Rezoning Transportation Analysis

Petition Number: 2023-034

Date	Description
06-28-23	First Review (TM)

RZ 1.0

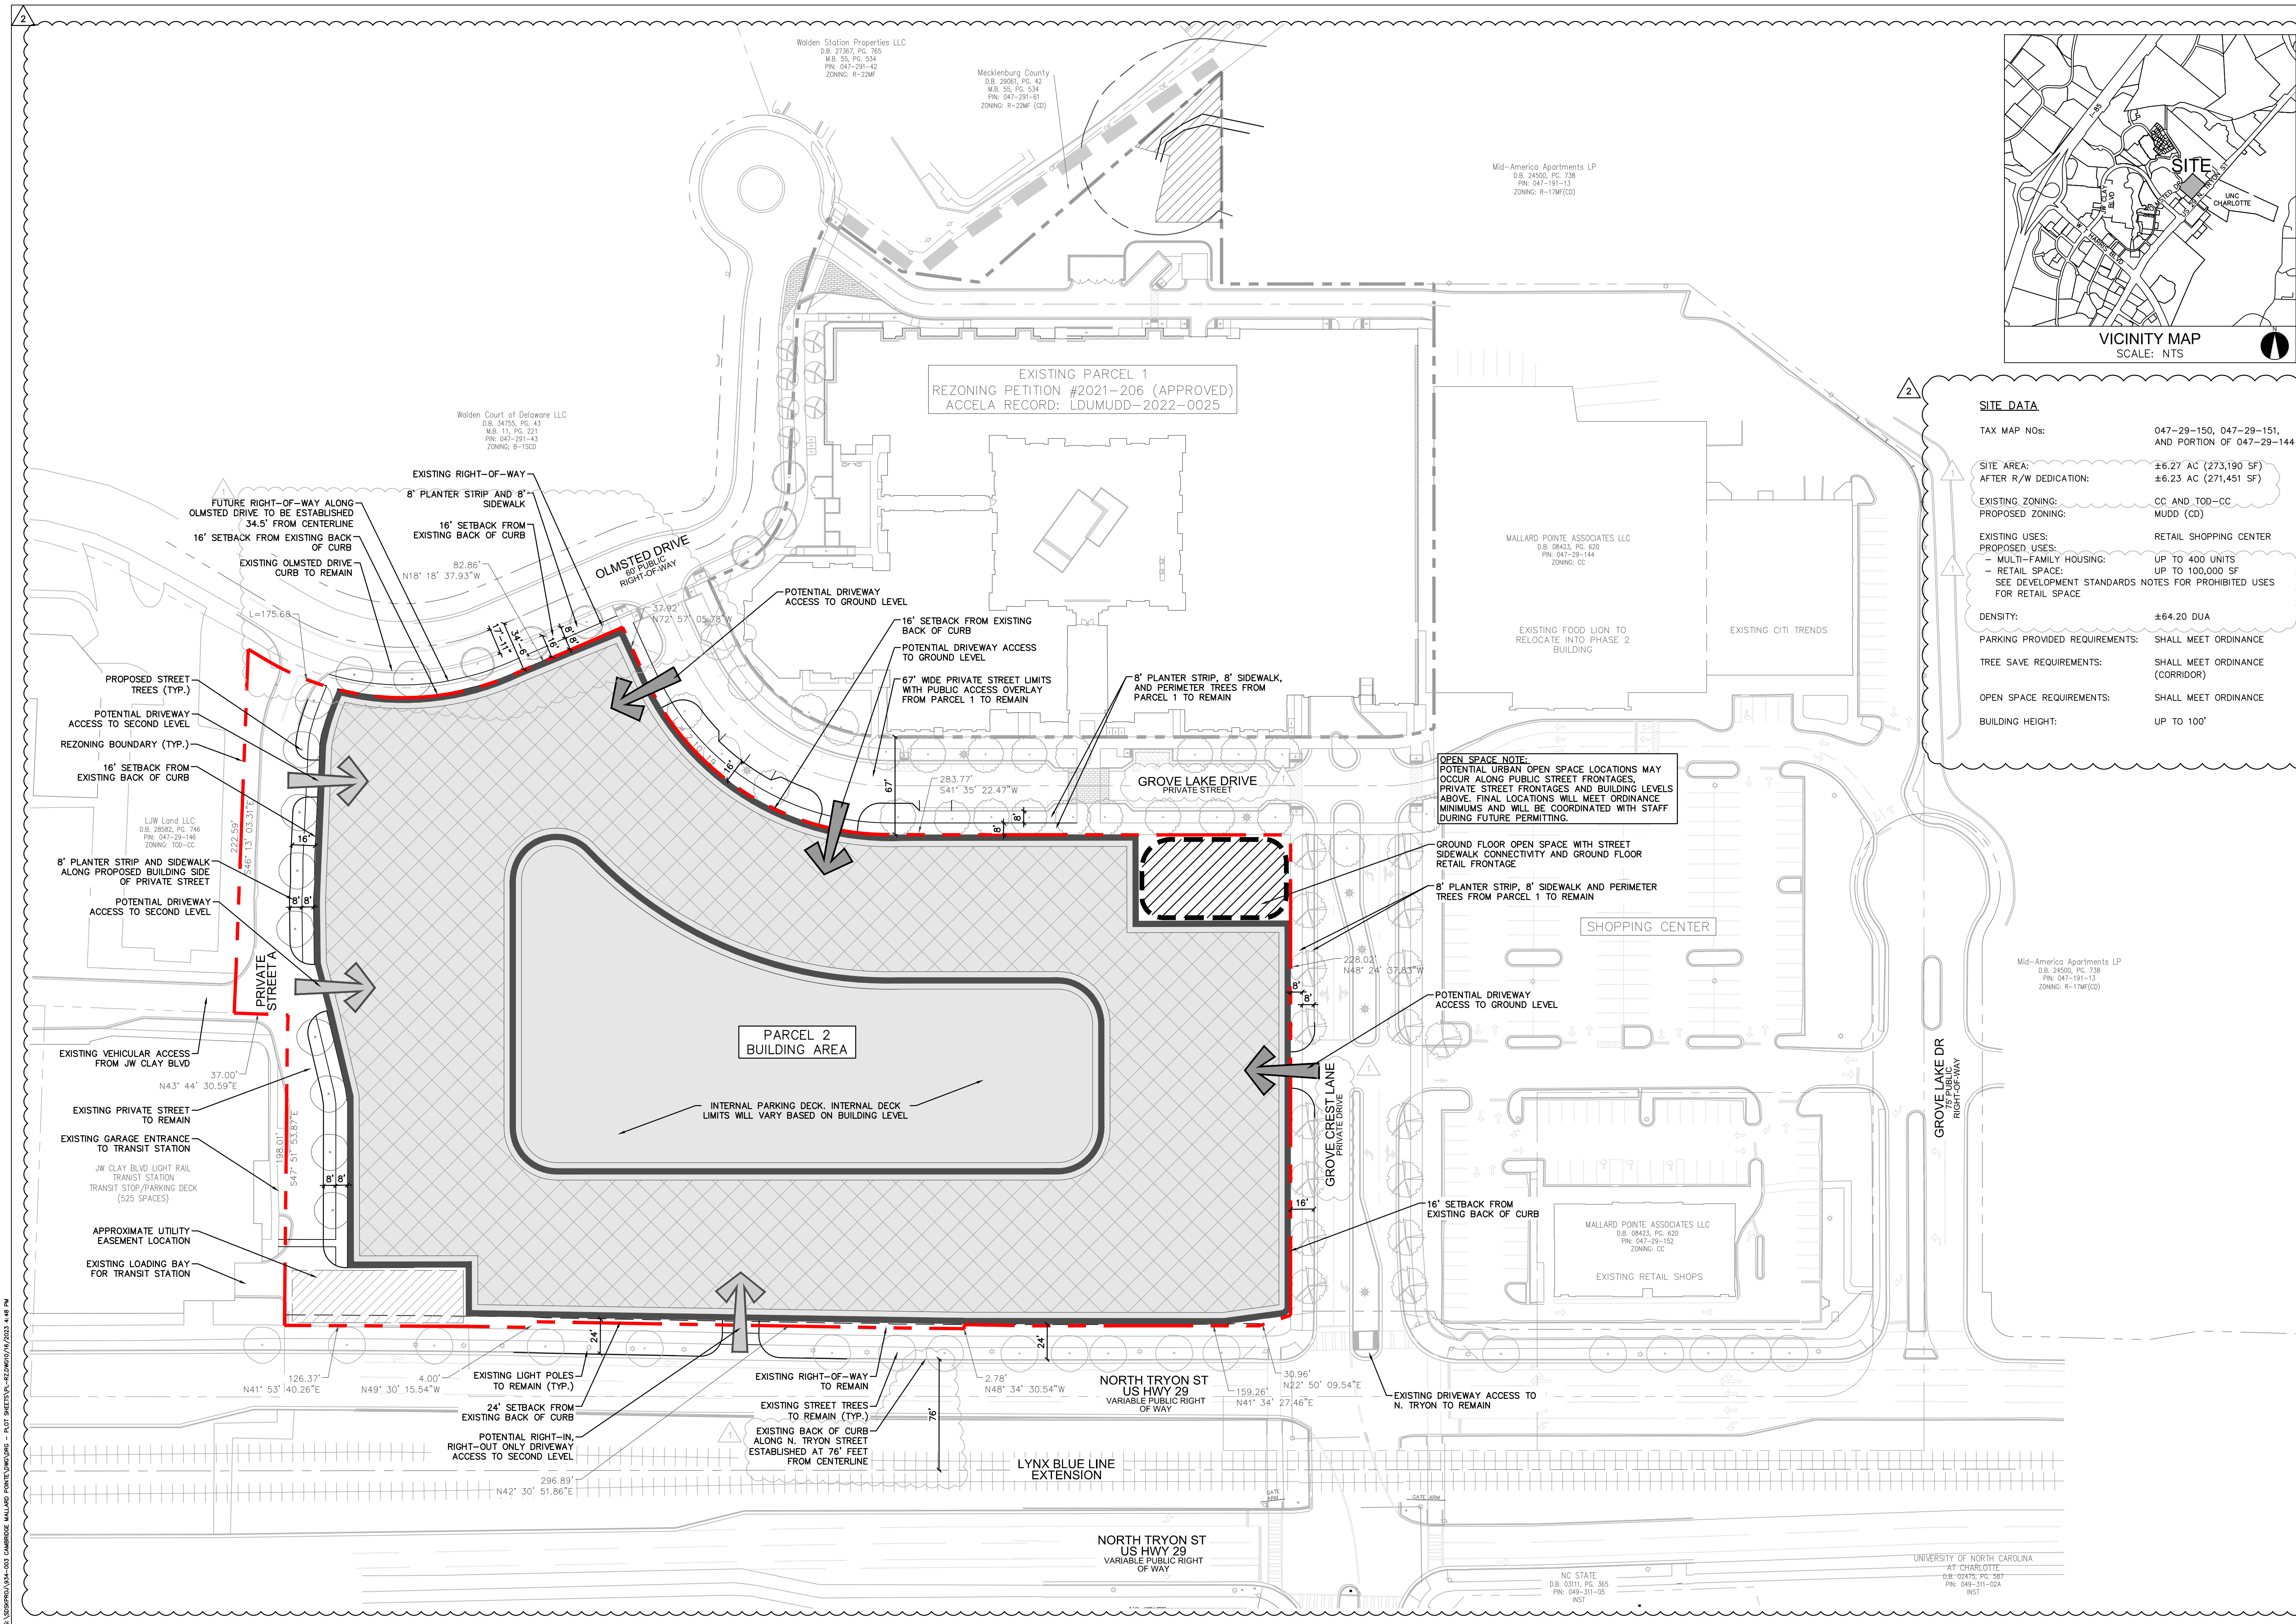
1. Curblines:

- Tryon Street:** The future location of curb and gutter is in its existing location.
- Olmsted Drive:** The future location of curb and gutter is in its existing location.

Label and dimension the curb and gutter from the centerline for each road on the site plan.

- Revise site plan and conditional note(s) to commit to dedicate a minimum of 34.5-feet of right-of-way from the road centerline of Olmsted Drive. The site plan shall label and dimension the right-of-way from the road centerline.
- Revise site plan and conditional note(s) to commit to construct an 8-foot planting strip, and 8-foot sidewalk on Olmsted Drive per Chapter 19. The site plan shall label and dimension both items from the back of curb and gutter or edge of pavement.
- The proposed dwelling units exceeds 12 per acre. Per Chapter 20 Subdivision ordinance, revise site plan and conditional note(s) to commit to construct an 8-foot planting strip, and 8-foot sidewalk along Olmsted Drive. The wider sidewalk also meets the Charlotte WALKS Policy.

7. Request: Revise site plan and conditional note(s) to commit to extending the 8-foot sidewalk on Olmsted Drive to J W Clay Boulevard CIP project.
8. Add a conditional note specifying "the Petitioner shall dedicate and convey in fee simple all rights-of-way to the City before the site's first building certificate of occupancy is issued. CDOT requests rights-of-way set at 2' behind back of sidewalk where feasible."
